COMMUNITY SERVICES DEPARTMENT

May 14, 2020

**Subject: Meadow Lake Commercial Park
(Rezone)**

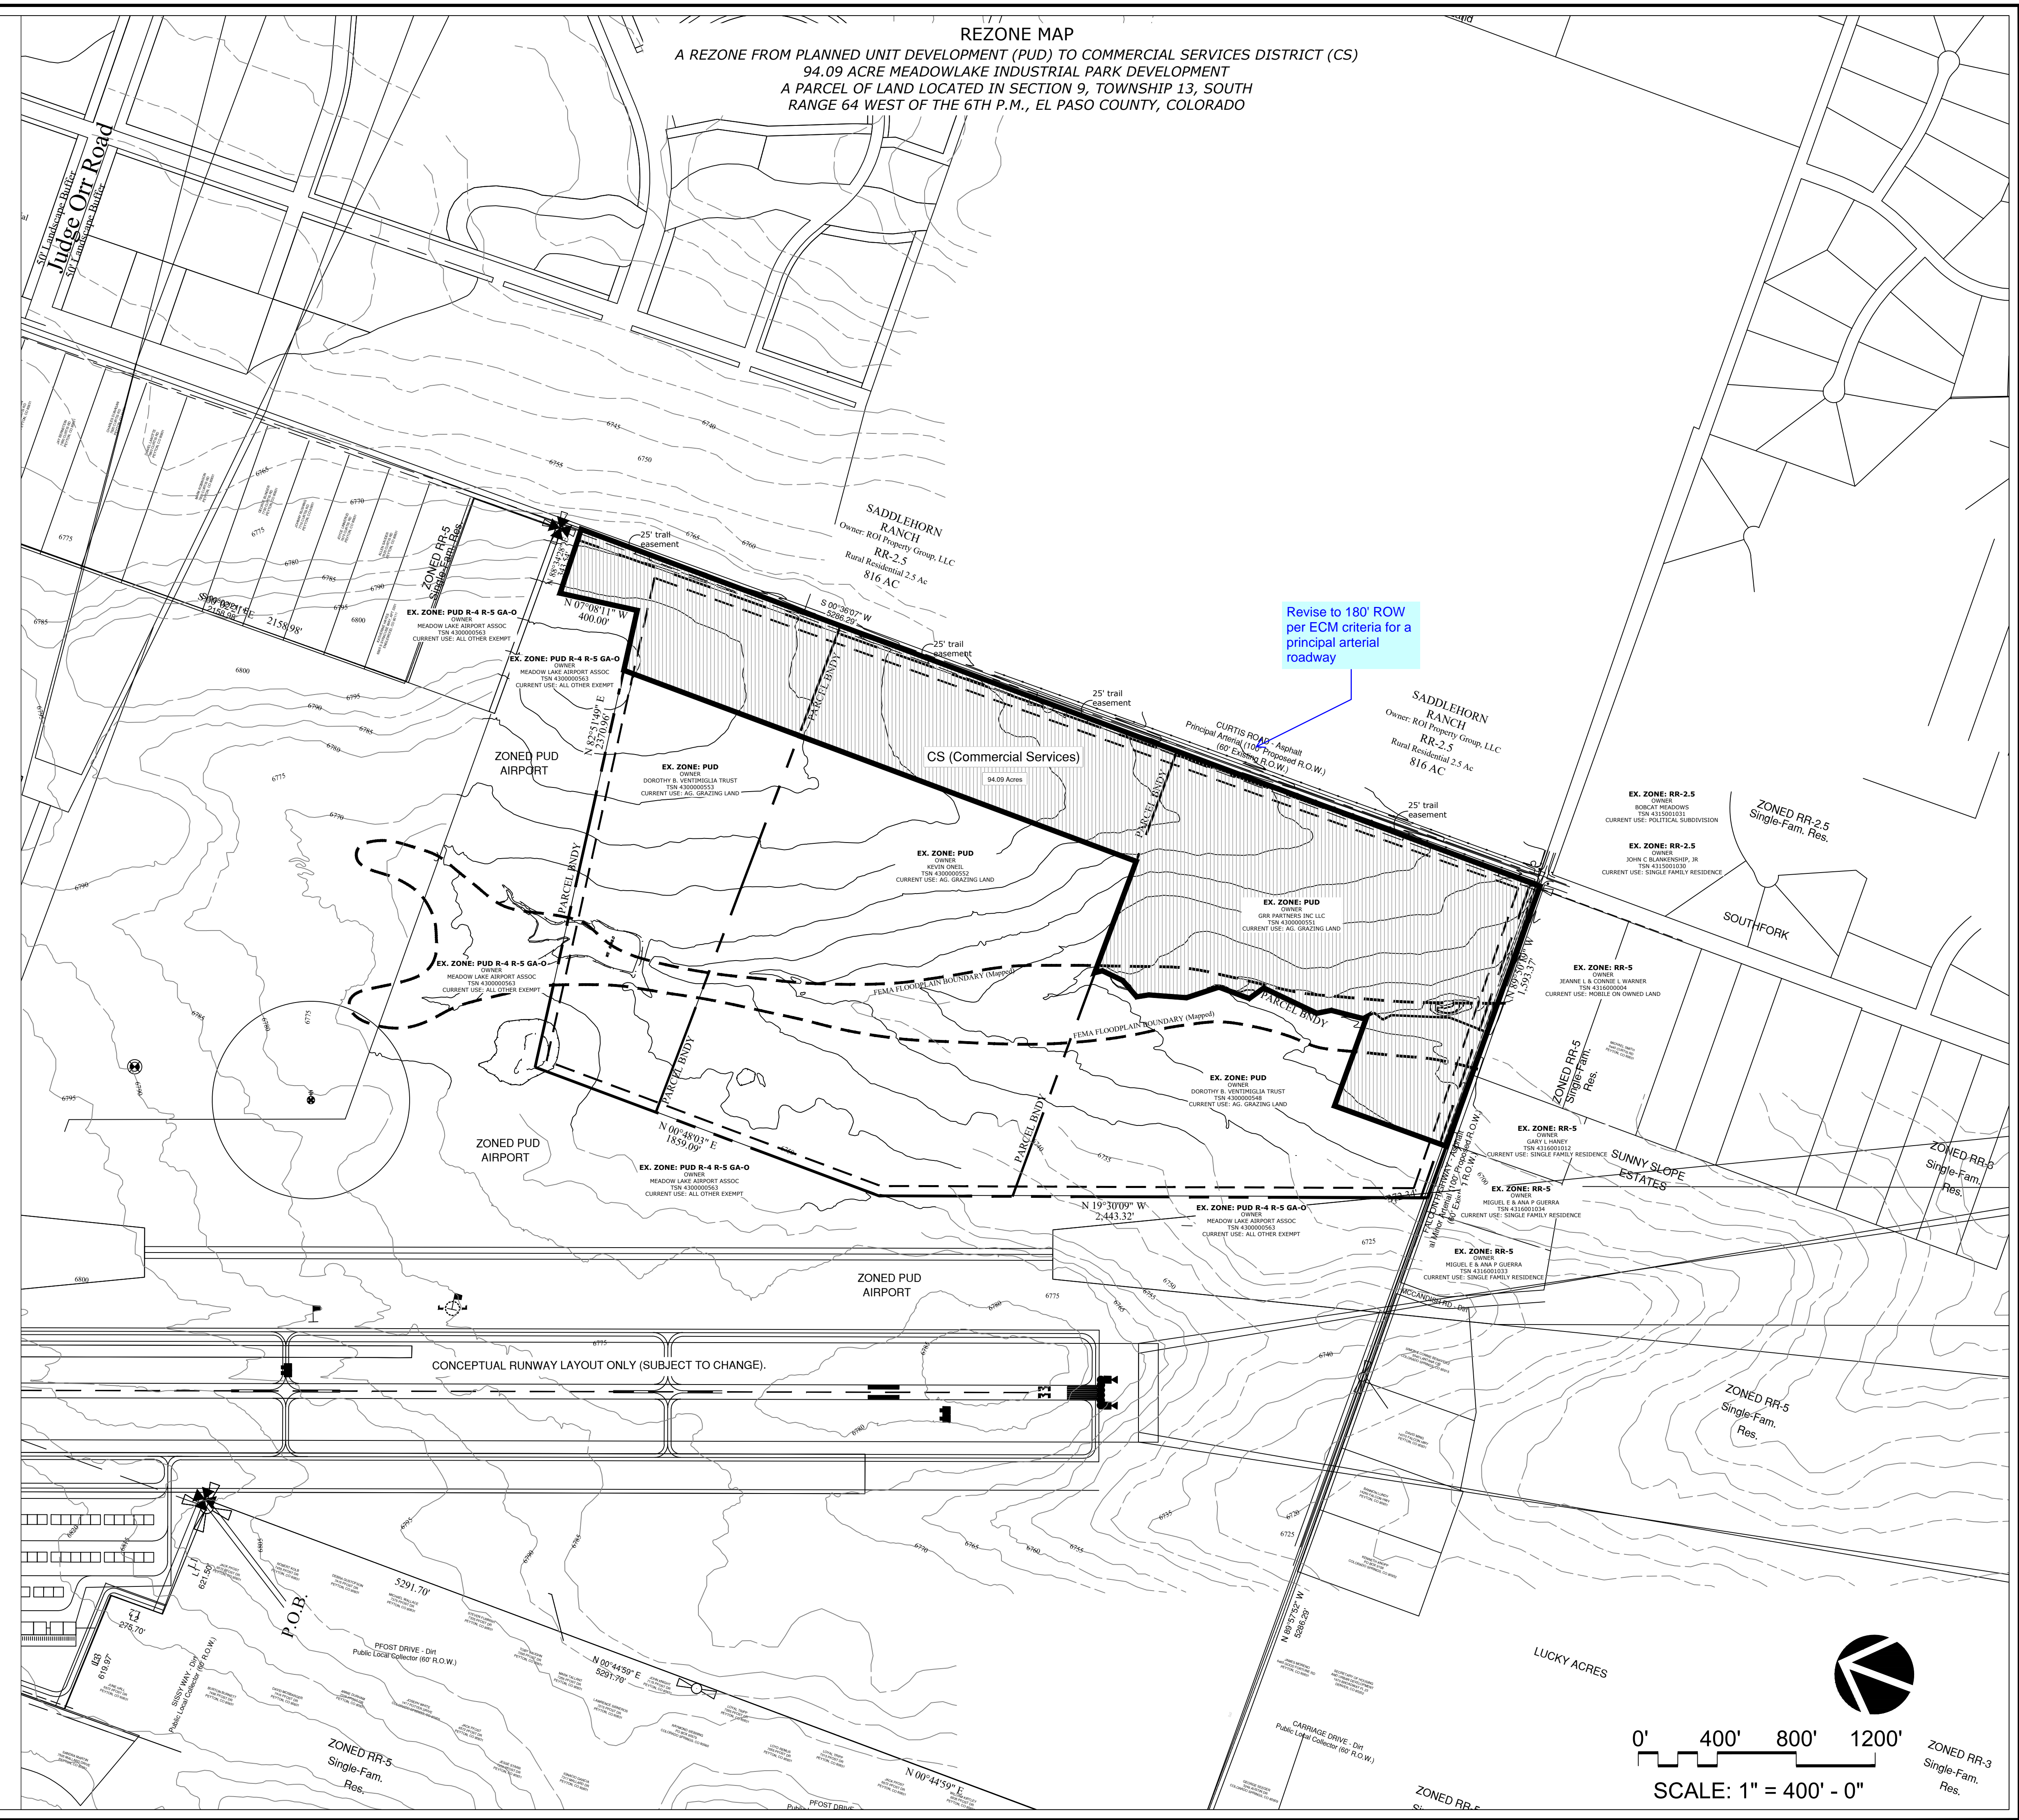
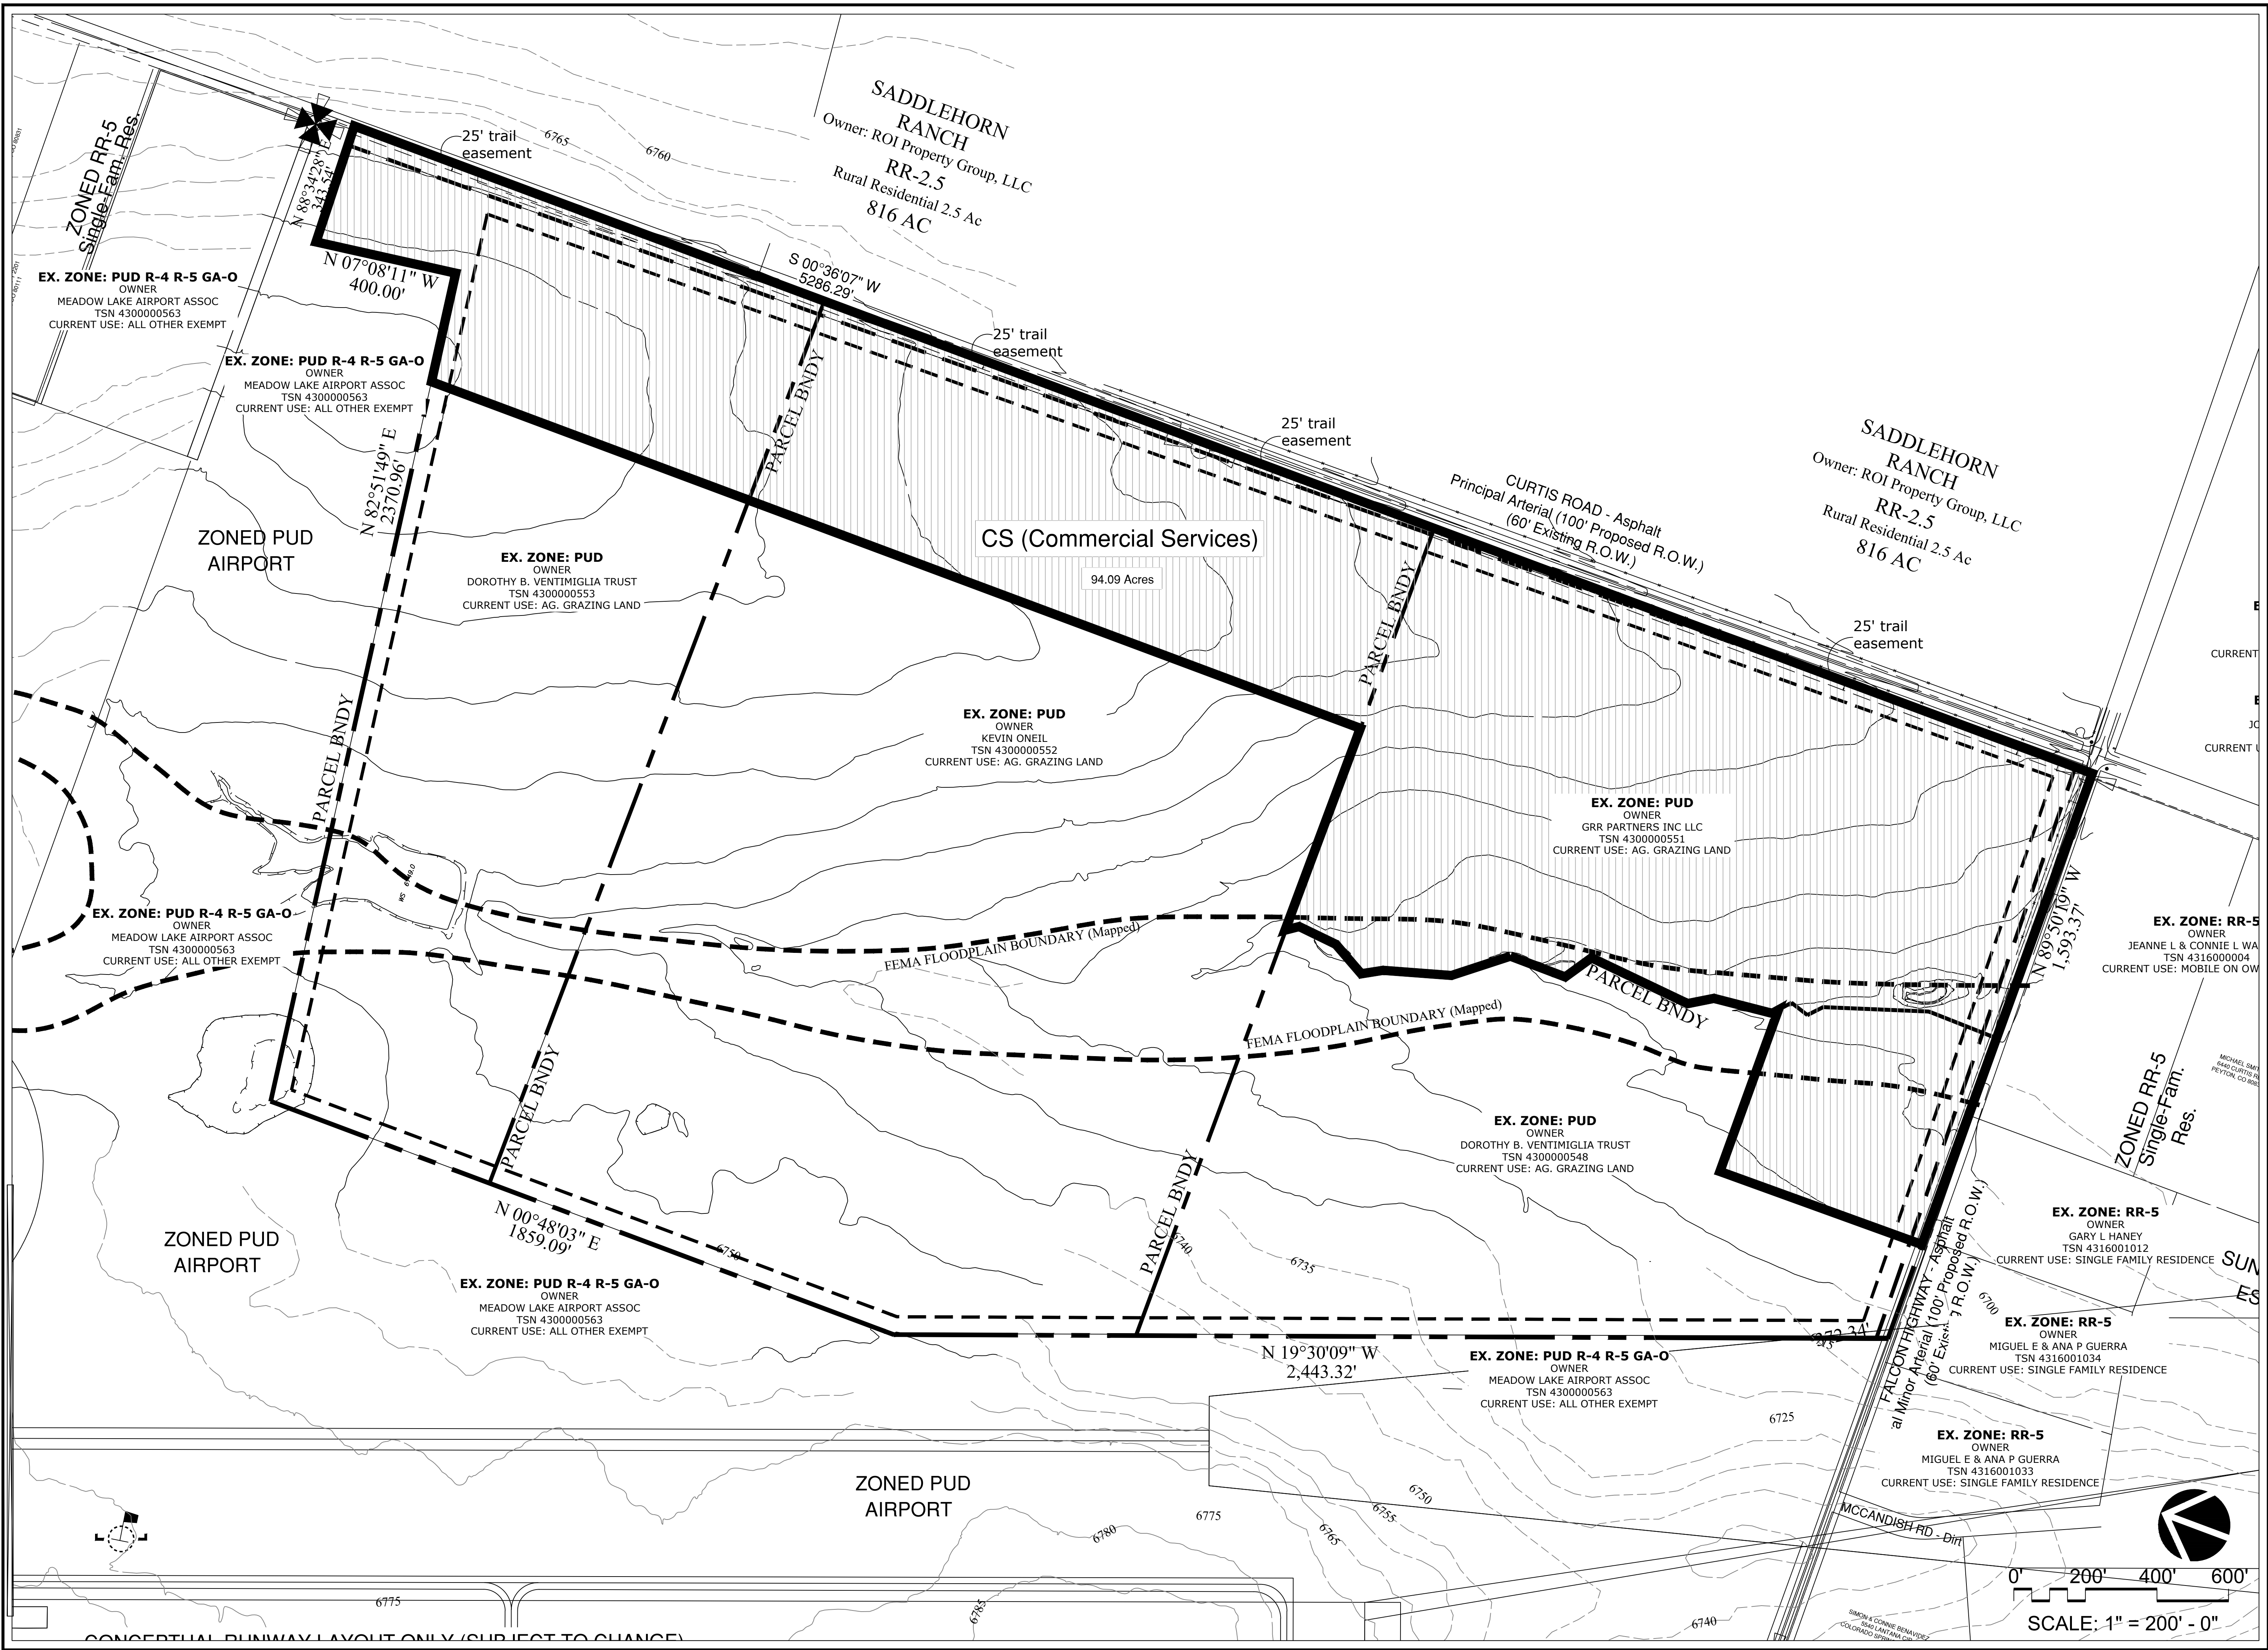
County Parks requests trail easements where development projects impact proposed County trails. As it pertains to this application, the applicant has proposed to relocate the Judge Orr Secondary Regional Trail from the unnamed creek to along Curtis Road to avoid a conflict with the Meadow Lake Airport. County Parks is in agreement with this proposal and requests the applicant provide a 25-foot public trail easement along the eastern boundary of the project site which will allow for the construction and maintenance by El Paso County of the Judge Orr Secondary Regional Trail, and this easement shall be shown and dedicated to El Paso County on the Rezone drawing and forthcoming CS Development Plan drawings.
